Rezoning Transportation Analysis

Petition Number: #2022-168

Date	Description
02-22-23	First Review (TM)
03-23-23	Second Review (TM)
04-20-23	Third Review (TM)

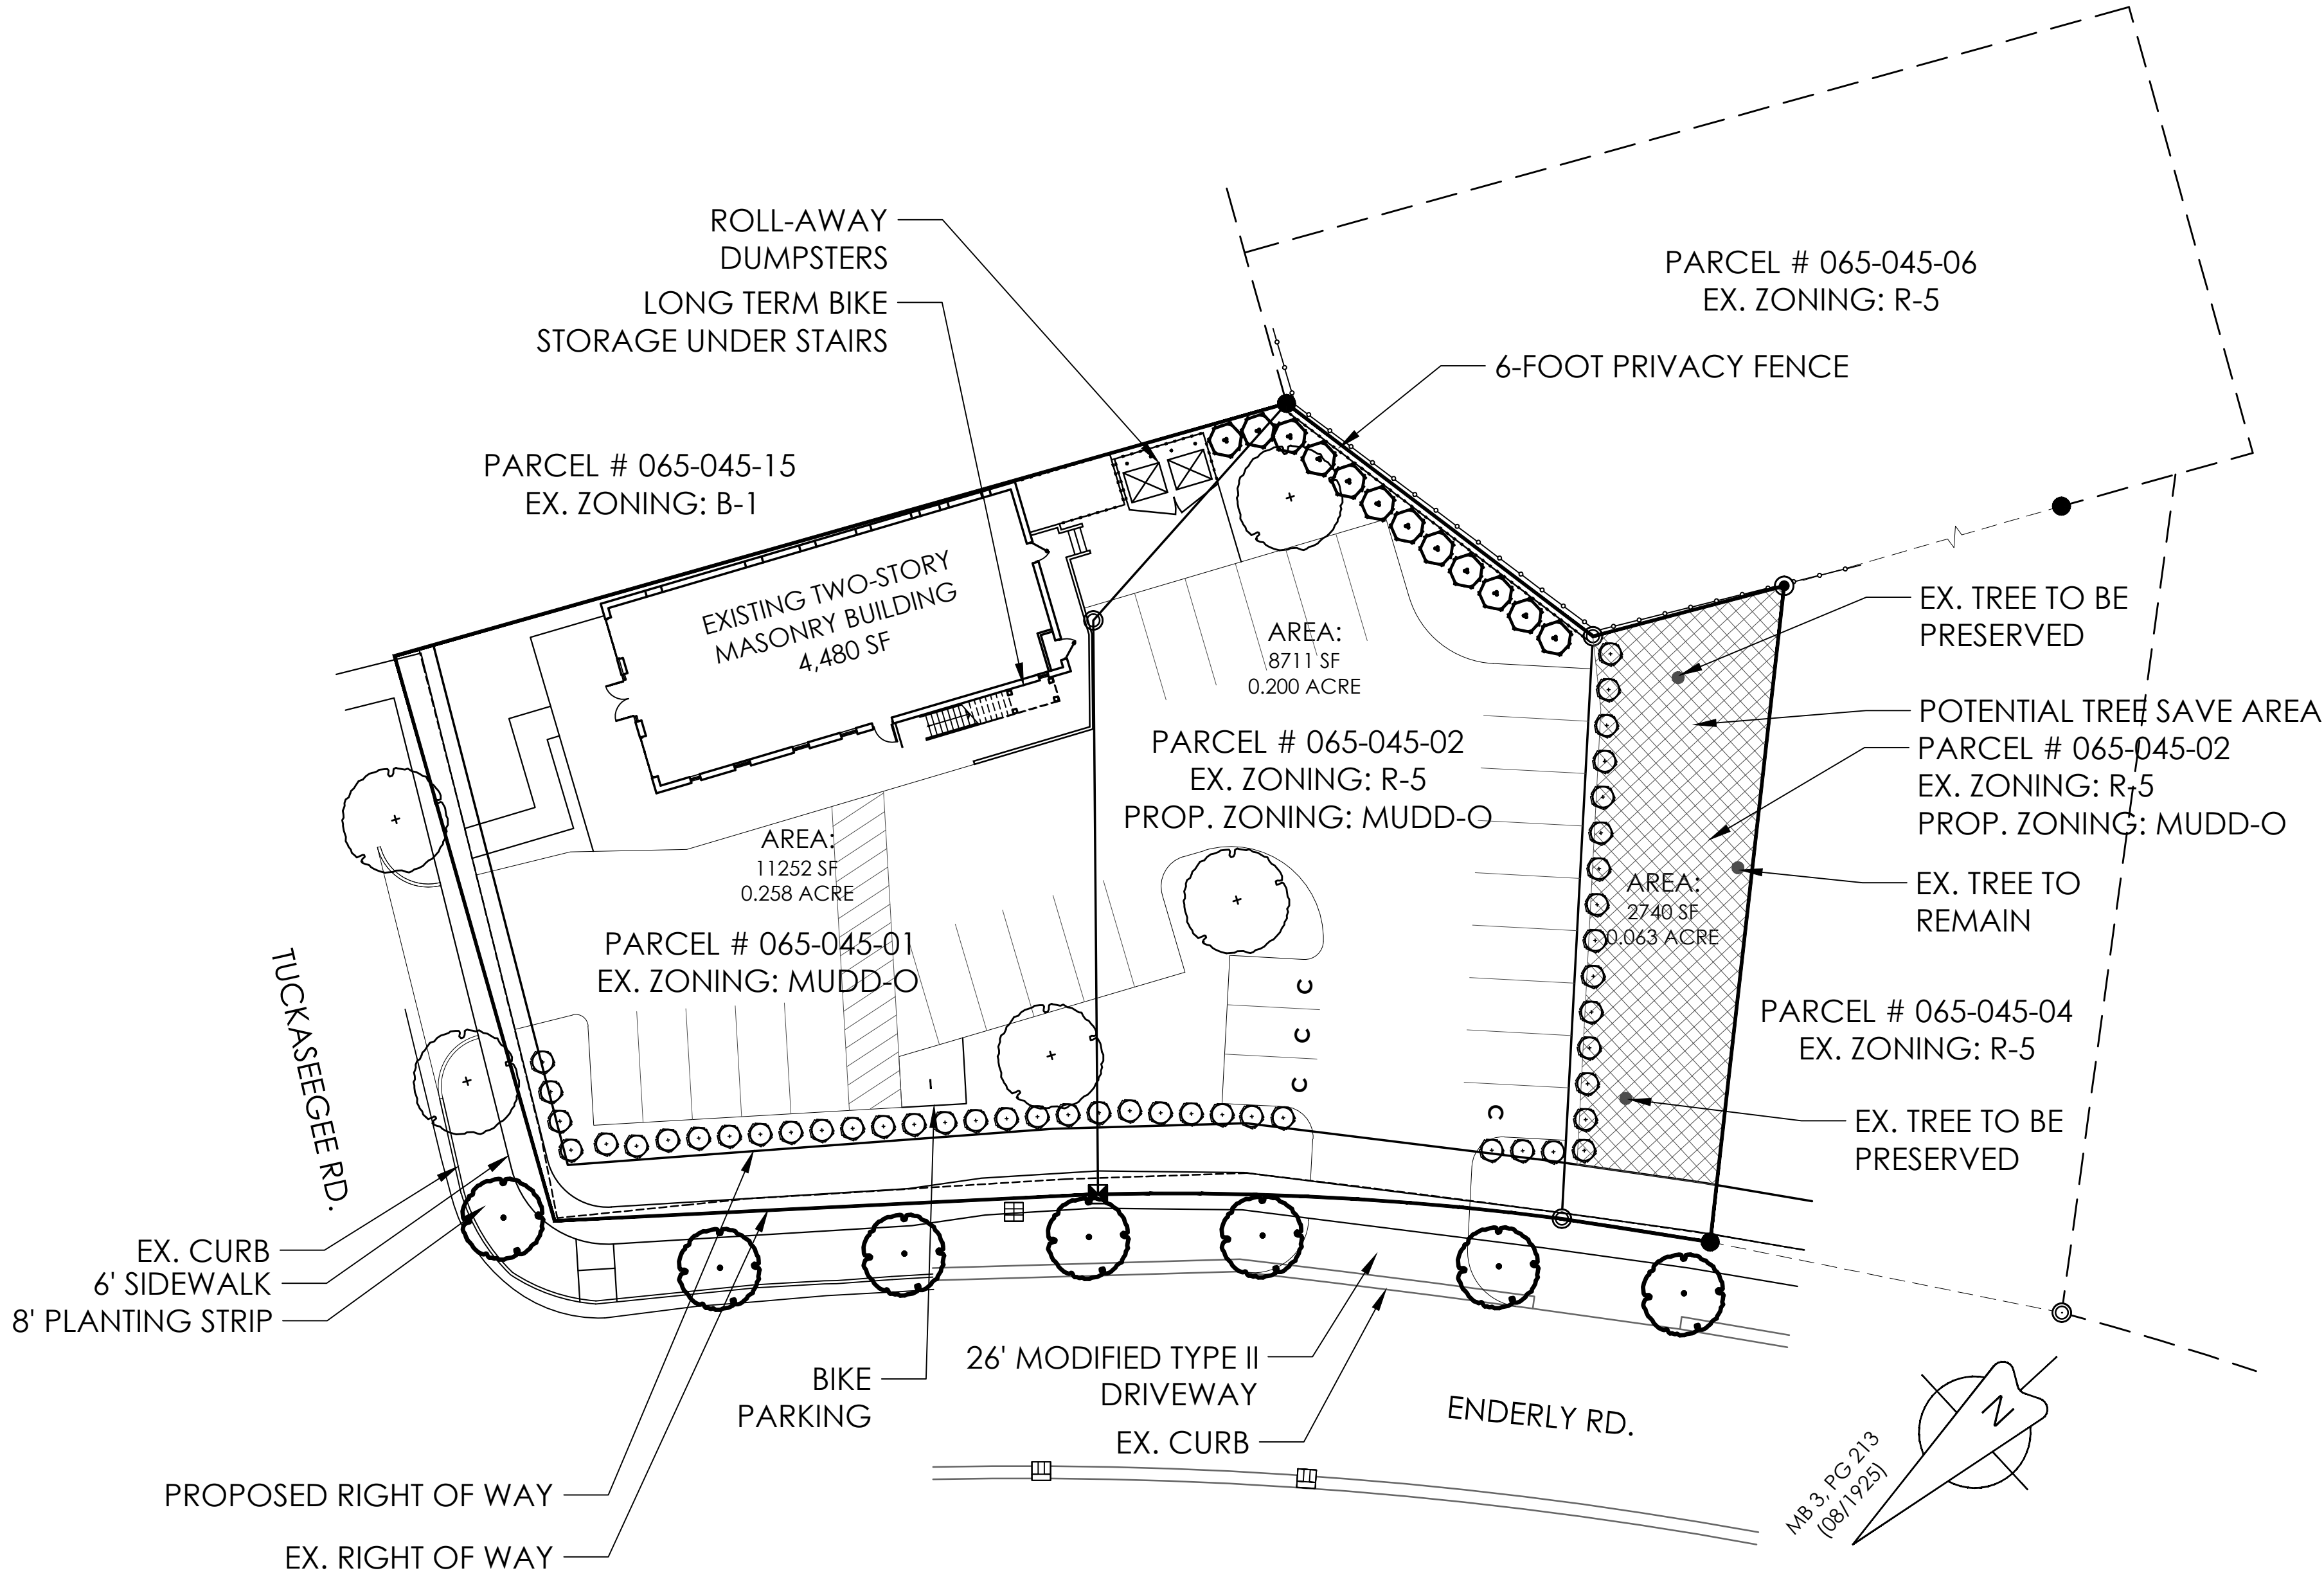
- a. **Outstanding Comment from 02-22-23: Tuckaseegee Road:** Location of curb and gutter to be moved to 27 feet from roadway centerline to accommodate the Charlotte Streets Map with a roadway typical section of a 2+ Avenue, Buffered/Separated Bike Lanes. Show future curb line on site plan and dimension planting strip and sidewalk from the future back of curb location.
- b. ~~**Enderly Road:** The future location of curb and gutter is in its existing location.~~

Outstanding Comment from 02-22-23: Label and dimension the curb and gutter from the centerline for each road on the site plan.

5. **CDOT REQUEST:** that site plan and conditional note(s) revisions are made to commit to construct an 8-foot planting strip, and 8-foot sidewalk on Tuckaseegee Road to match the overall city plan for this street section per Charlotte's Streets Map. The site plan shall label and dimension both items from the future back of curb and gutter. The wider sidewalk also meets the Charlotte WALKS Policy

6. **Outstanding Comment from 02-22-23:** Add a conditional note specifying "A Right-of-Way Encroachment Agreement is required for the installation of any non-standard item(s) (irrigation systems, decorative concrete pavement, brick pavers, etc.) within a proposed/existing City-maintained street right-of-way by a private individual, group, business, or homeowner's/business association. An encroachment agreement must be approved by CDOT prior to construction/installation. Contact CDOT for additional information concerning cost, submittal, and liability insurance coverage requirements."
